Our Case Number: ABP-314232-22

Re: DART+ West Railway Order - Dublin City to Maynooth and M3 Parkway
County Dublin, County Meath, County Kildare

Re: DART + West Electrified Railway Order 2022
Third Party Observation ref. CIE / Irish Rail works to railway tracks
around Croke Park
Ref. No. 314232

On behalf of our client Páirc an Chrocaigh Teoranta of Croke Park Stadium, Jones Road, Dublin 3, SSA Architects (agent) of 42 Haddington Road, Dublin 4, wish to make the following observations in relation to the proposed CIE/Irish Rail works upgrade the 2 railway lines from a new Spencer Dock station to beyond Maynooth.

Drawing Number: **MAY MDC LAN ROUT DR U 15102 D**

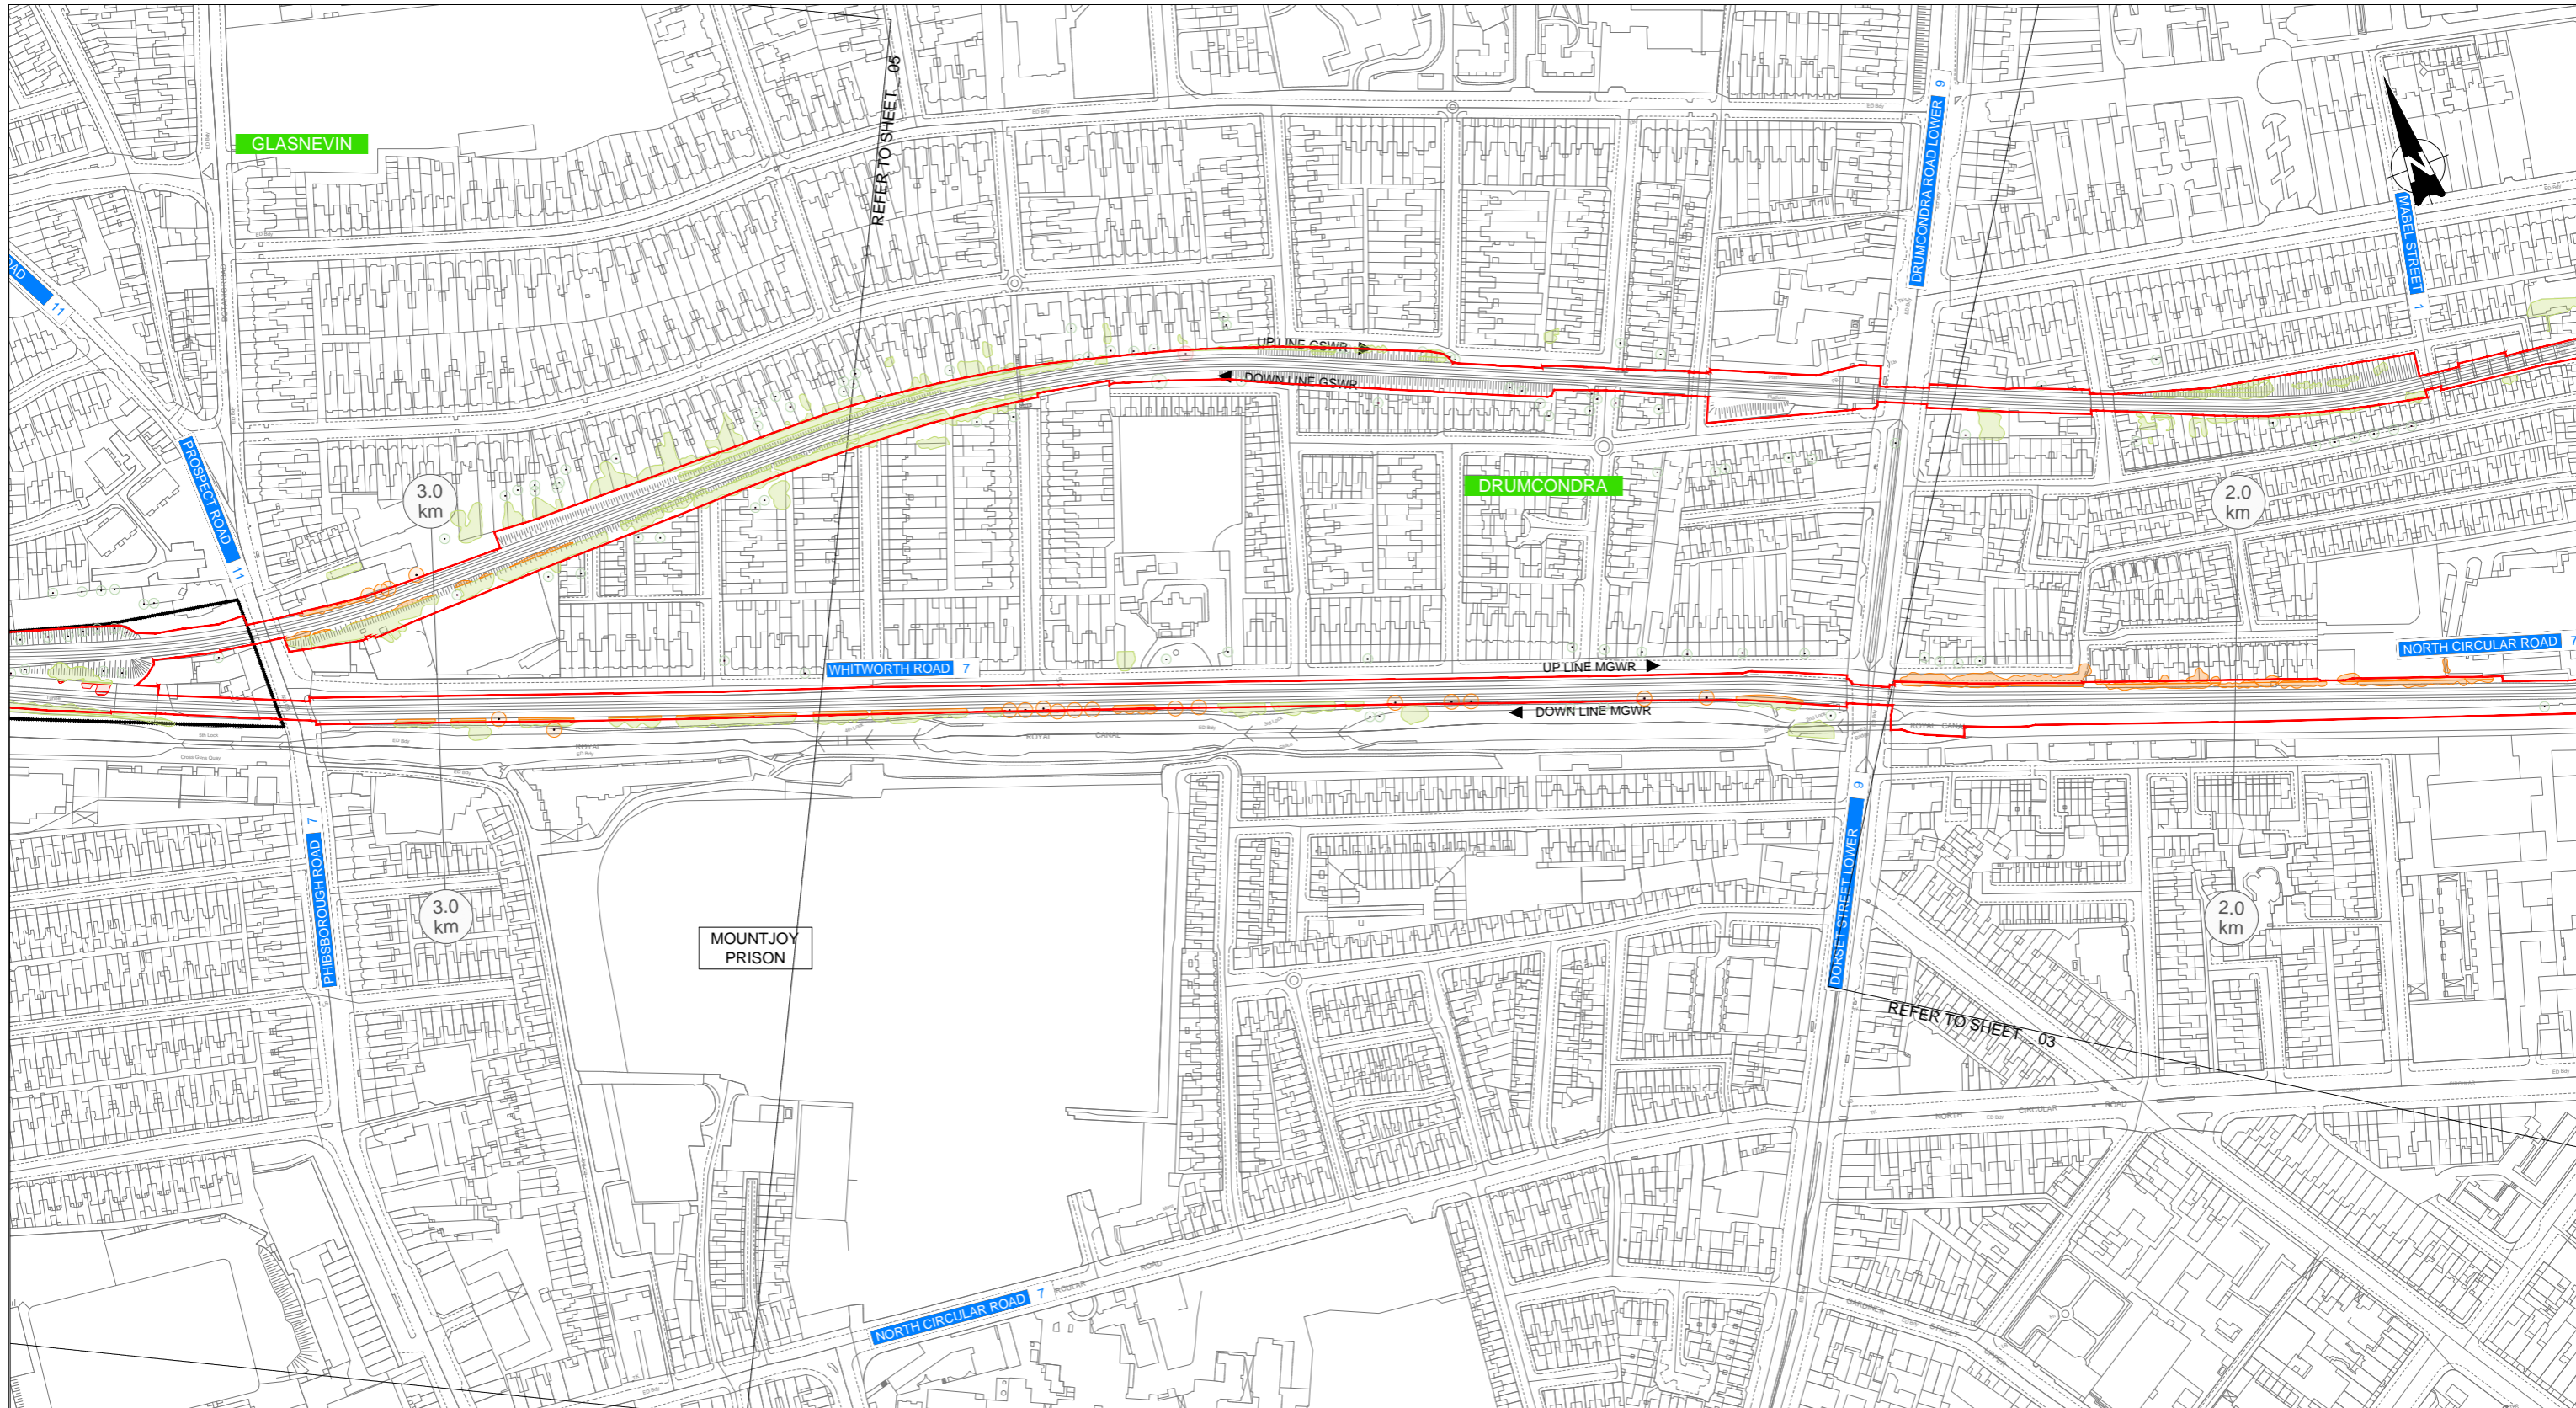
There is some confusion in that one description of the works talks about a temporary acquisition of the Love Lane area in order to facilitate reinforcement of the boundary treatment. However, a further drawing (LAN15102) illustrates a permanent boundary extended beyond the Love Lane area. I suspect that the latter is an error but nonetheless this needs to be confirmed with CIE.

A second issue relates to the question of whether there is a permanent or temporary acquisition of Love Lane.
